Ribble Valley Borough Council
Housing & Development Control

Your ref: 3/2022/1158
Our ref: D3.2022.1158
Date: 23rd November 2023

Application no: **3/2022/1158**

Address: **Land South of Accrington Road Whalley**

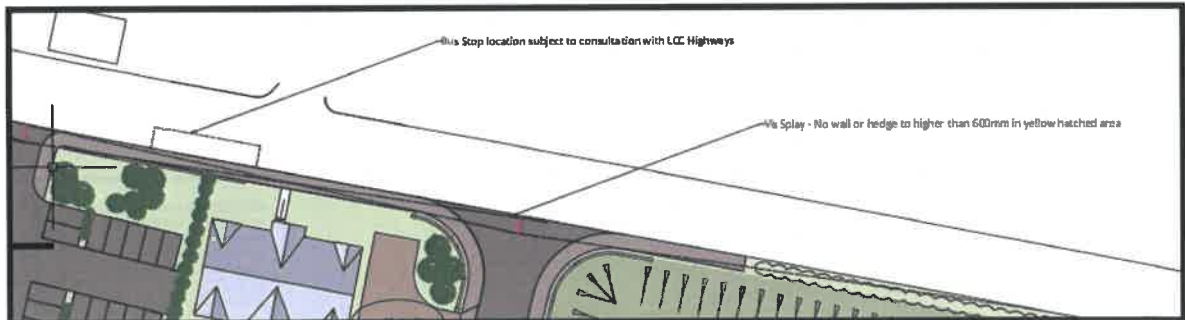
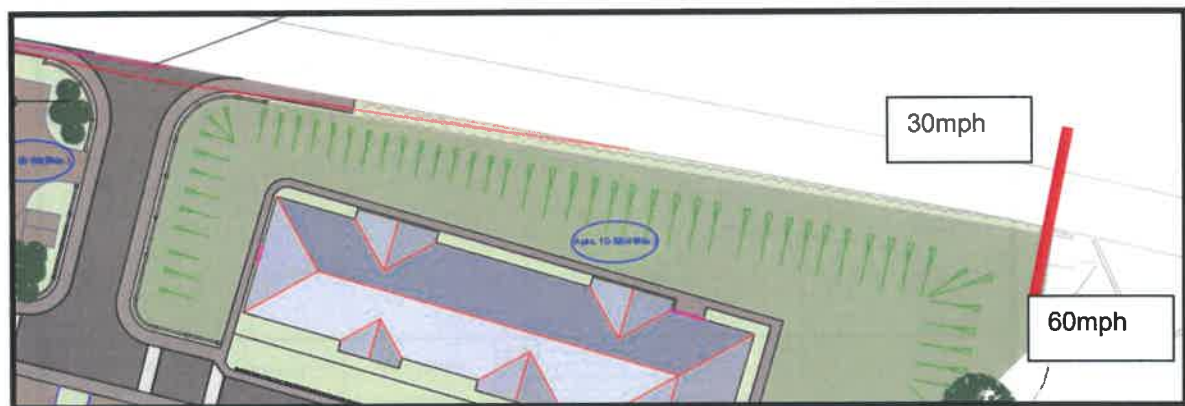
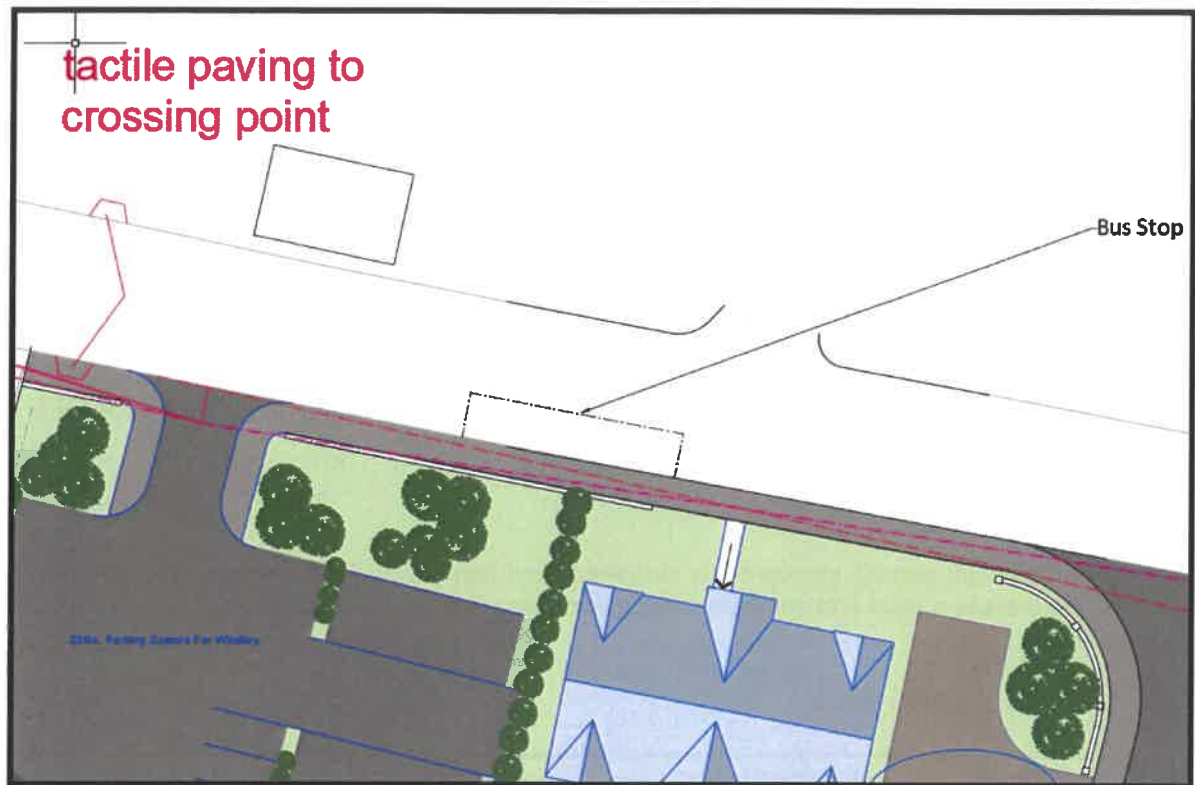
Doyle Transport drawing number P434/15/002- Plan 1 Rev A has shown that the residential junction can provide visibility splays of 2.4m x 70m in both directions. The LHA accepted these visibility splays as part of application reference 3/2012/0179 which was for a similar scale of development and so accept the use of these splays to support the application.
